Principal Areas of Disagreement Summary Statement (PADSS)

Version Number: 2

Submitted at: Deadline 2: 26 March 2024

This statement has been prepared by Horsham District Council (“the Council”) with input from the joint local authorities, technical consultants and legal specialists. The Northern Runway Project application was submitted to the Planning Inspectorate on 6 July 2023 and accepted for Examination on 3 August 2023. The Council is one of the local authorities identified by Section 43(2) of the Planning Act 2008 and in response to the Examining Authority’s (“ExA”) Procedural Decision letter of 8 September 2023 to the Applicant and the Host and Neighbouring Authorities, the Council has prepared this Principal Areas of Disagreement Summary Statement (“PADSS”) (Version 2). This Statement identifies the principal areas of disagreement and is considered to be a live document.

Diagram 3.3.1: Model performance before and after adjustment, Generic zone

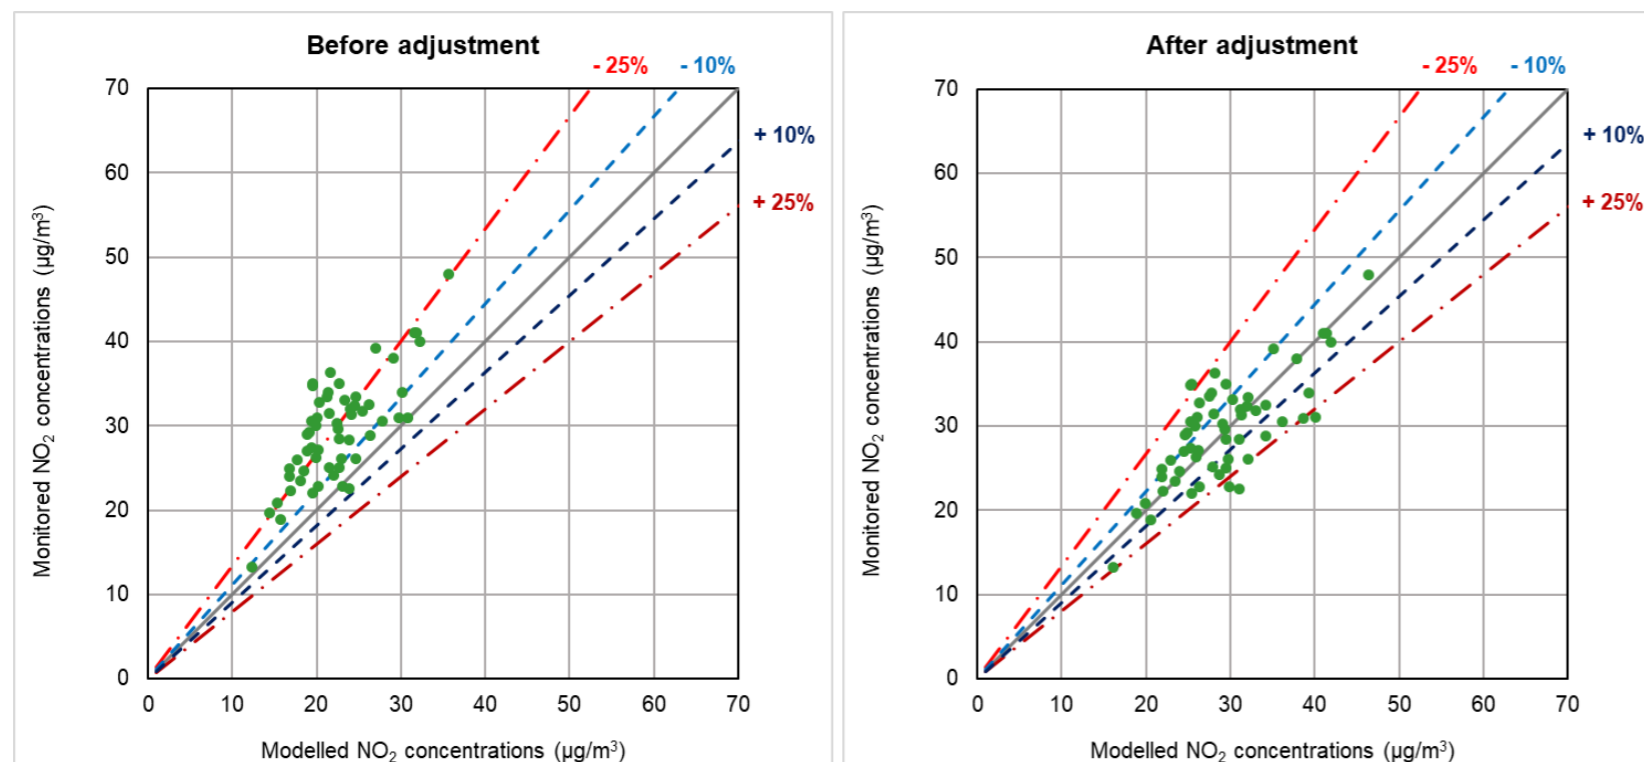
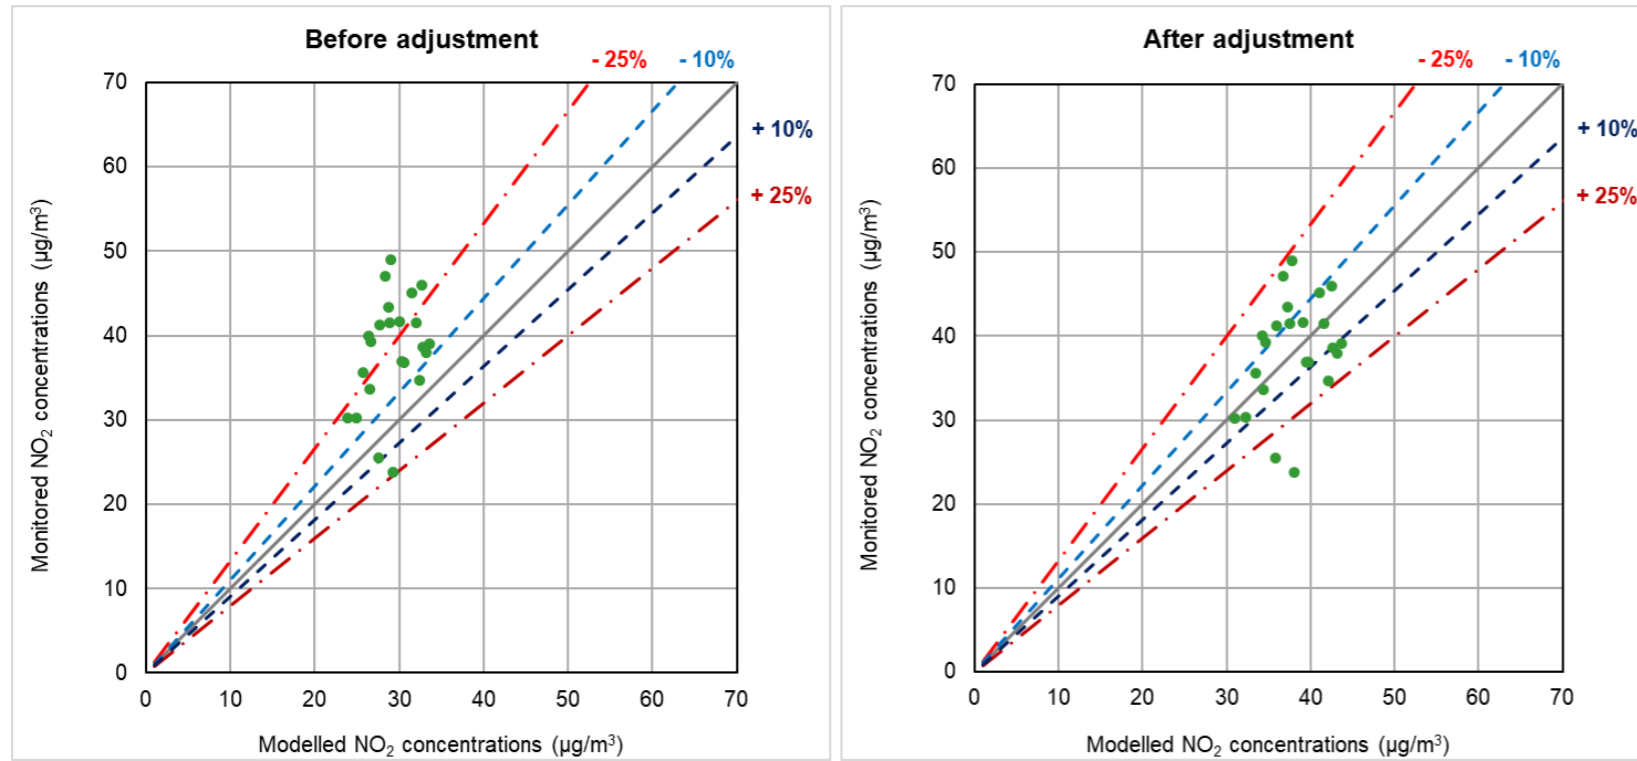
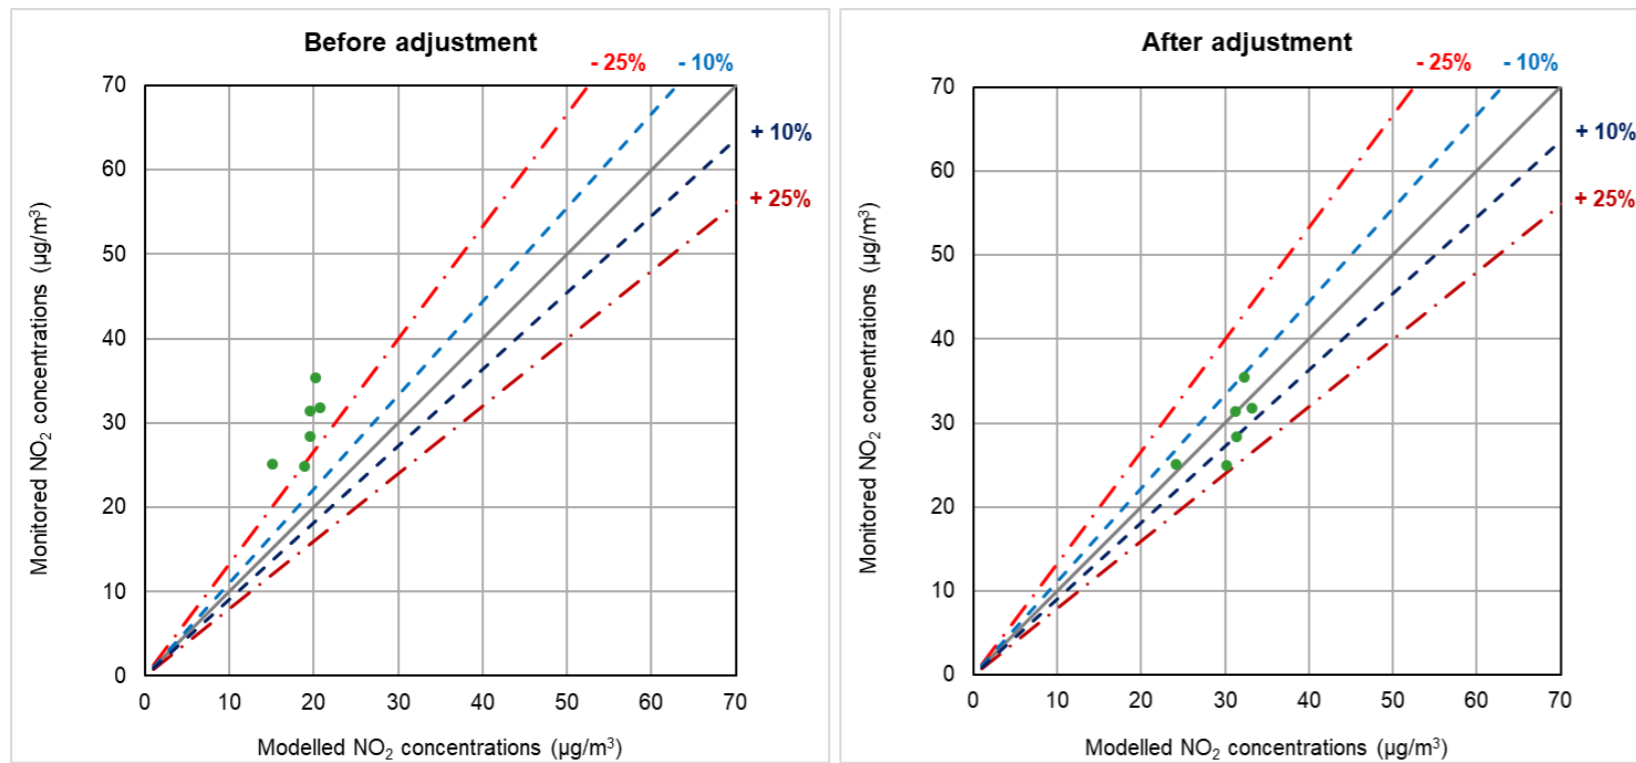
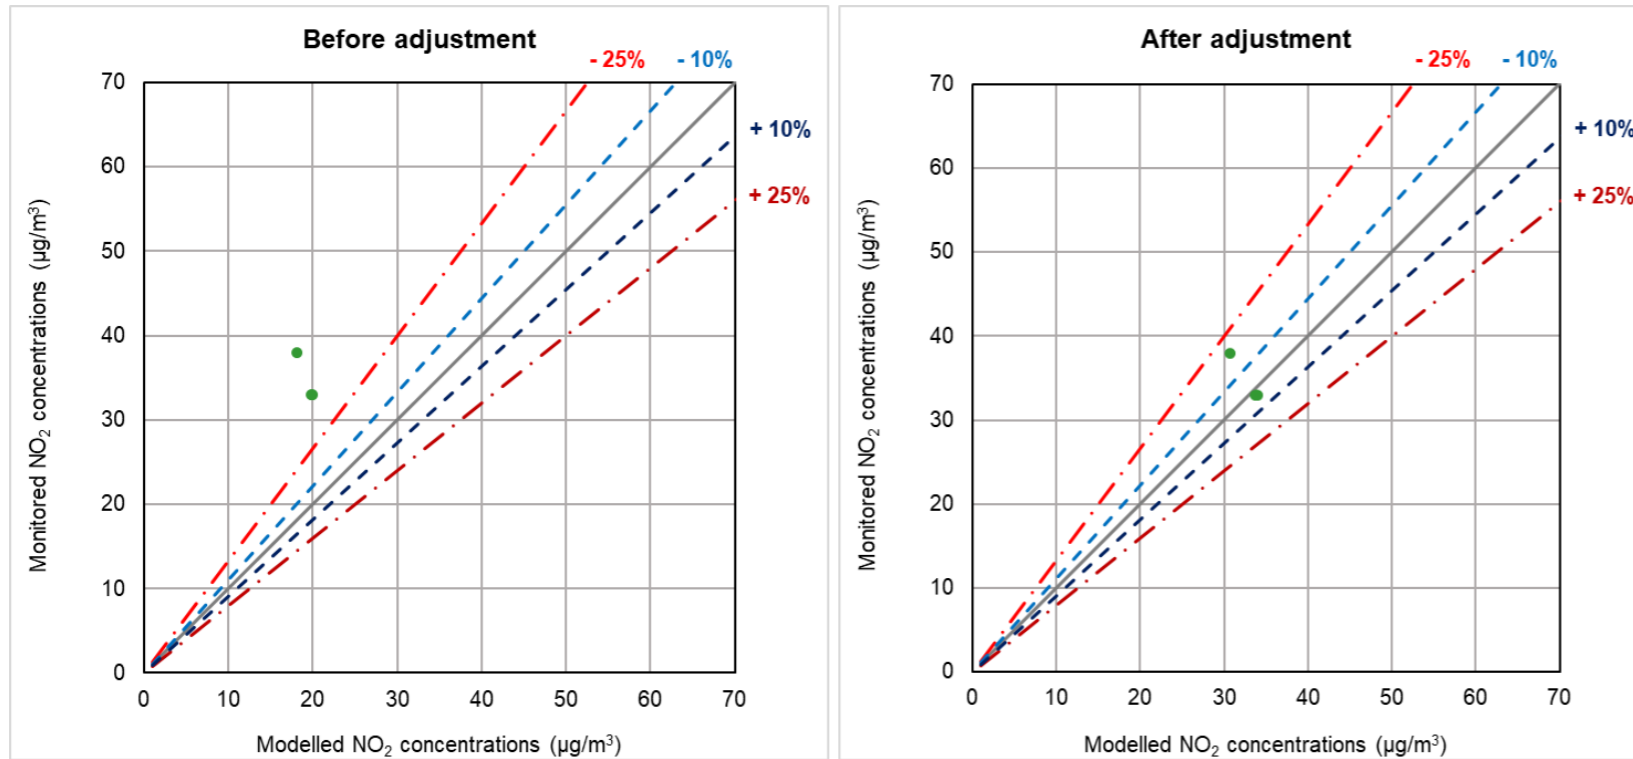
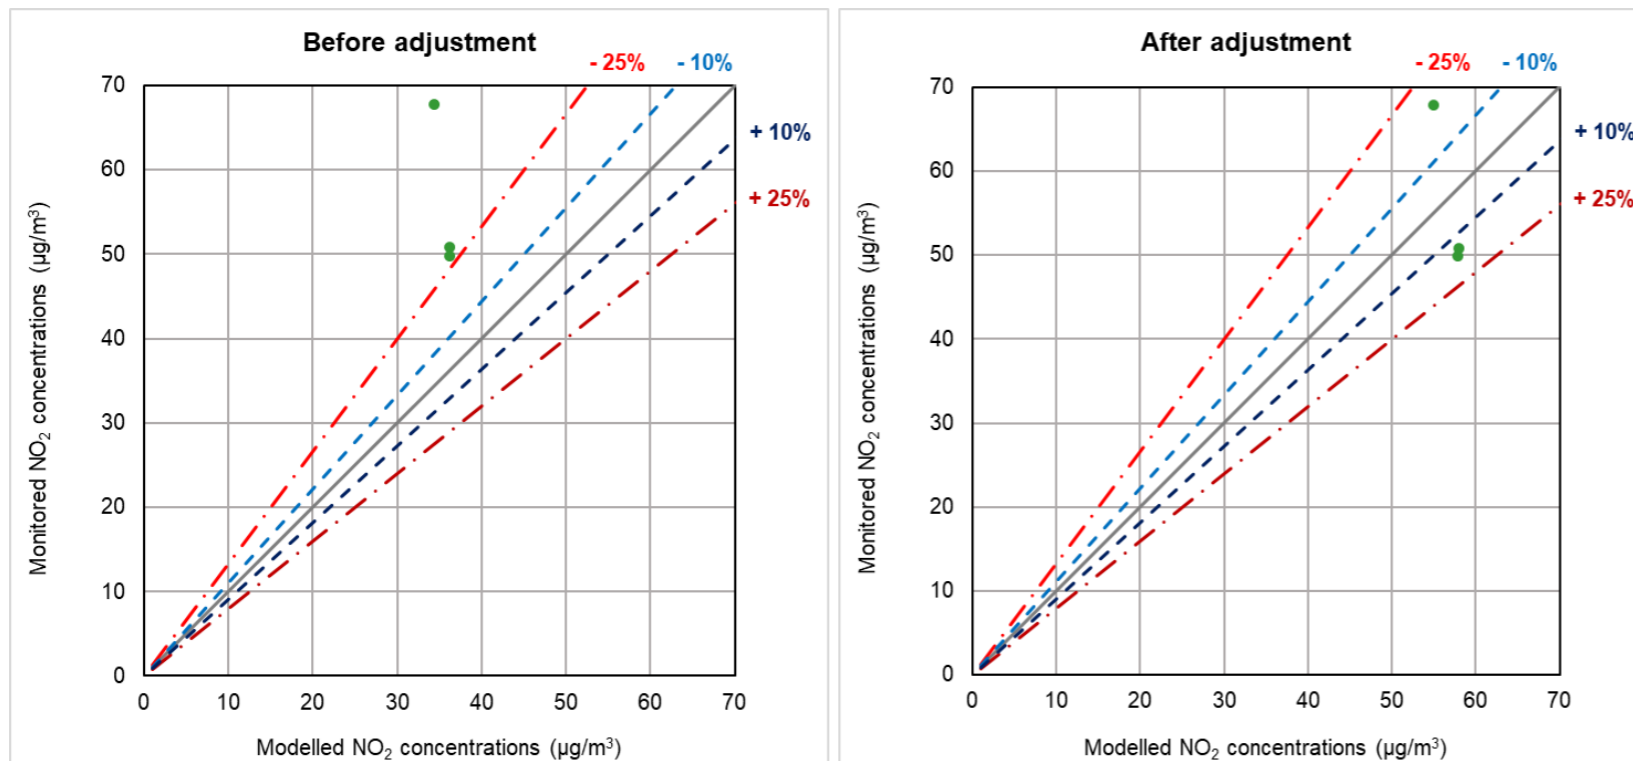
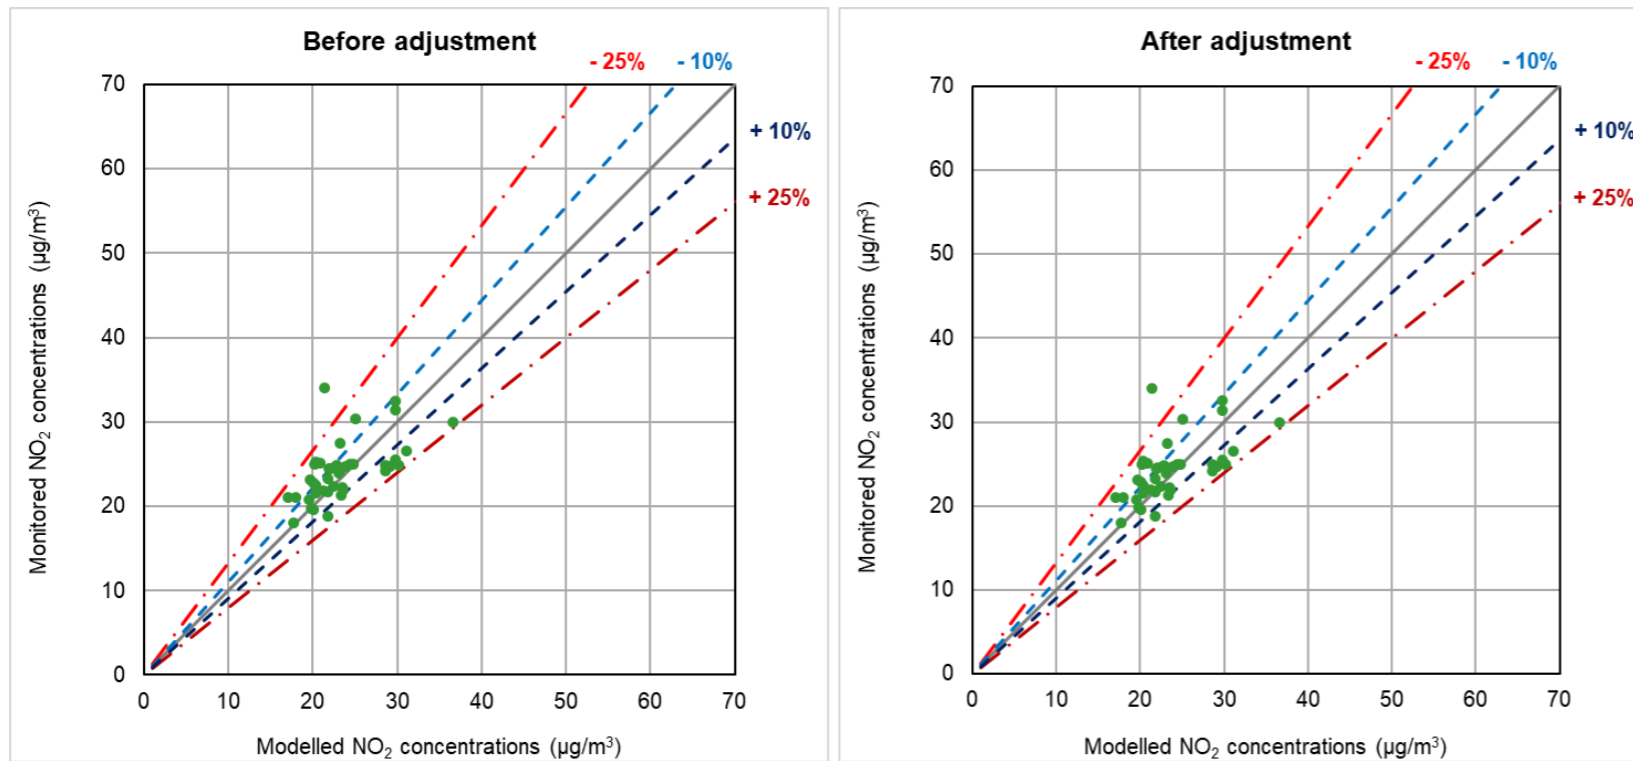
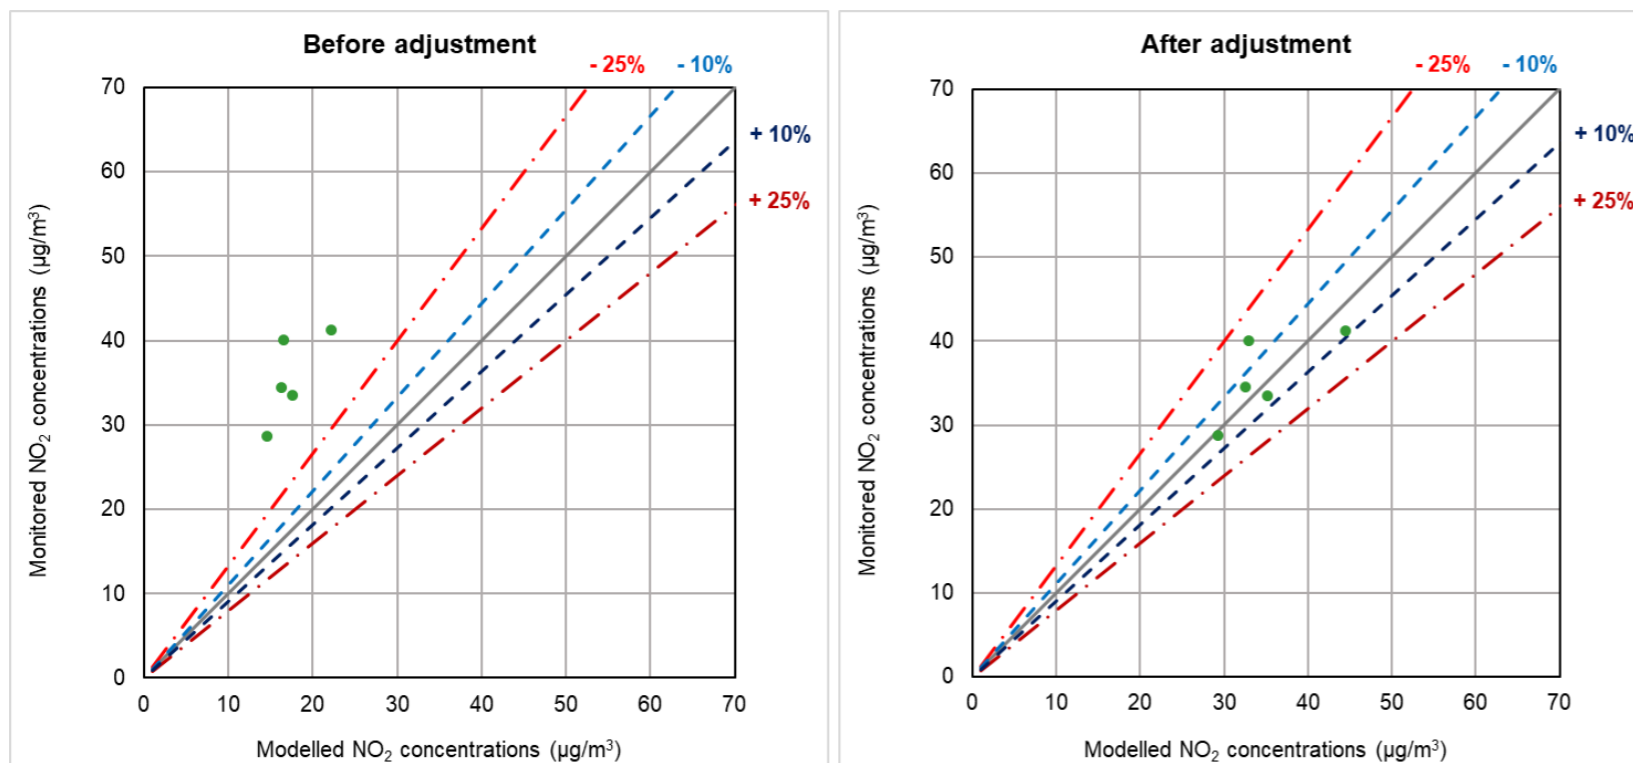
3.5	Model Set Up and Methodology	Regarding model verification, Appendix 13.6.1: Air Quality Data and Model verification is missing details on how model verification factors for the selected zones were established. Details are required of the initial	The Applicant should provide further details in relation to the model verification	Uncertain

HDC Ref.	Principal Issue in Question	Concern held	What needs to change / be amended / be included in order to satisfactorily address the concern?	Likelihood of concern being addressed during Examination
		<p>verification including Monitored Road NOx Contribution versus Unverified Modelled Road NOx, which monitoring sites were used, and which were removed from the verification process.</p> <p>To facilitate the scrutiny of the model set up and any assumptions used, it is requested that a complete set of input files be shared for 2018 (Base Year) and 2029 (nearest future year). In addition, Operational and Construction impacts for 2029 should be modelled jointly as one scenario, in order to enable the evaluation of all impacts associated with the development.</p>
